**Document name:** 231022-EDGE-XX-XX-CO-C-0002\_THAMES WATER RESPONSE [P01]

**Re:** THAMES WATER RESPONSE – Drainage Comments – 148–154 High Street, Uxbridge – 78696/APP/2024/867.

Appendix E – Proposed drainage layout

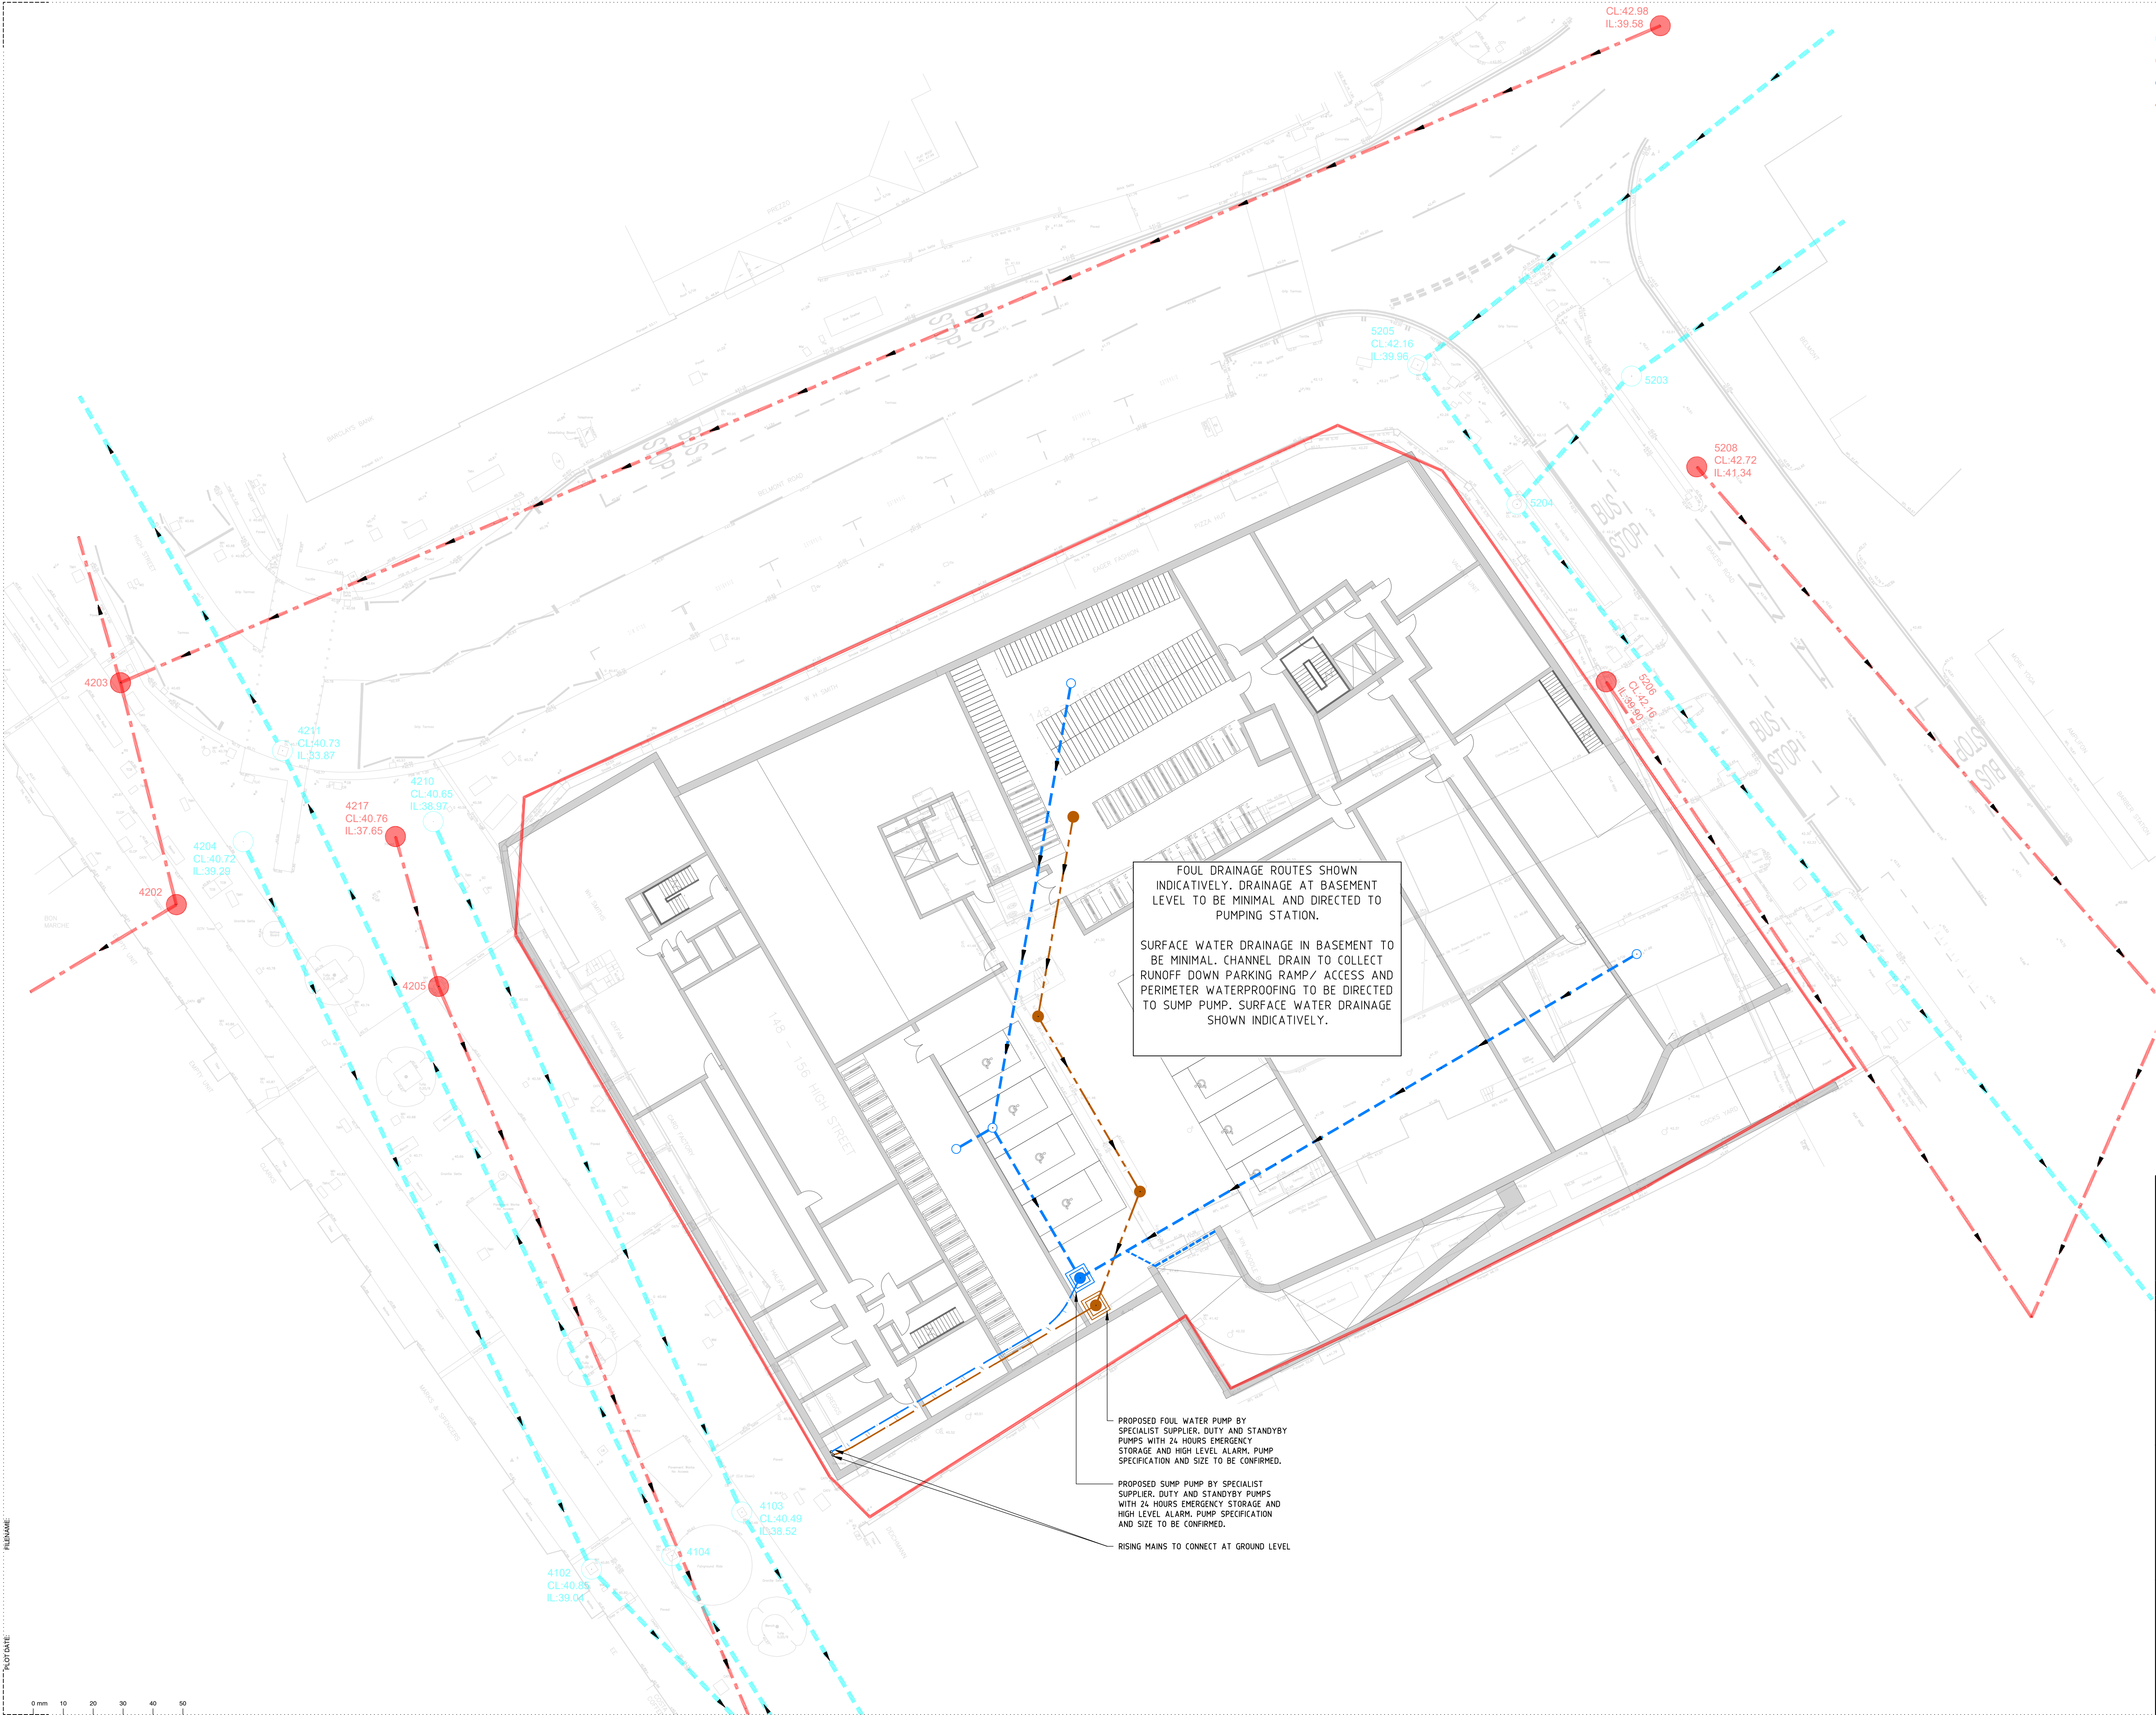
1. *As required by Building regulations part H paragraph 2.36, Thames Water requests that the Applicant should incorporate within their proposal, protection to the property to prevent sewage flooding, by installing a positive pumped device (or equivalent reflecting technological advances), on the assumption that the sewerage network may surcharge to ground level during storm conditions.*

2. *If as part of the basement development there is a proposal to discharge ground water to the public network, this would require a Groundwater Risk Management Permit from Thames Water. Any discharge made without a permit is deemed illegal and may result in prosecution under the provisions of the Water Industry Act 1991. We would expect the developer to demonstrate what measures will be undertaken to minimise groundwater discharges into the public sewer.*

3. *Thames Water would recommend that petrol / oil interceptors be fitted in all car parking/washing/repair facilities. Failure to enforce the effective use of petrol / oil interceptors could result in oil-polluted discharges entering local watercourses.*

4. *There are public sewers crossing or close to your development. If you're planning significant work near our sewers, it's important that you minimize the risk of damage.*

1. Its not clear from the comment how this will work in practise and how a pumped device will protect the site from flooding due to downstream sewer surcharge. For example, where will the pump discharge to? Assume to the public sewer? However, the assumption is that this sewer is surcharged. Therefore, we will be pumping in a perpetual loop until storms subsides. We have requested input and technical guidance from Thames Water developer services and the Thames water development planning team on this.

2. Basement waterproofing proposals are not yet developed however any ground water discharge to public sewers will be in accordance with Thames Water approval with all relevant applications and permits obtained ahead of works commencing.

3. Interceptor is proposed within the basement to cleanse all runoff within the car park prior to discharge to the public surface water sewer.
4. The proposals do not include any changes to building footprint so there should not be an increased risk to Thames Water assets. Nevertheless, a sewer investigation/ survey has been undertaken to determine the position and depth of public sewer assets. This information will feed into any proposals to work near the sewers with all necessary protection measures being adhered to. All connections to be reused or new connections made will be under strict accordance with section 106 approval from Thames Water. Guidance notes provided by Thames Water will be fully reviewed and adhered to during detailed design stage and construction works.
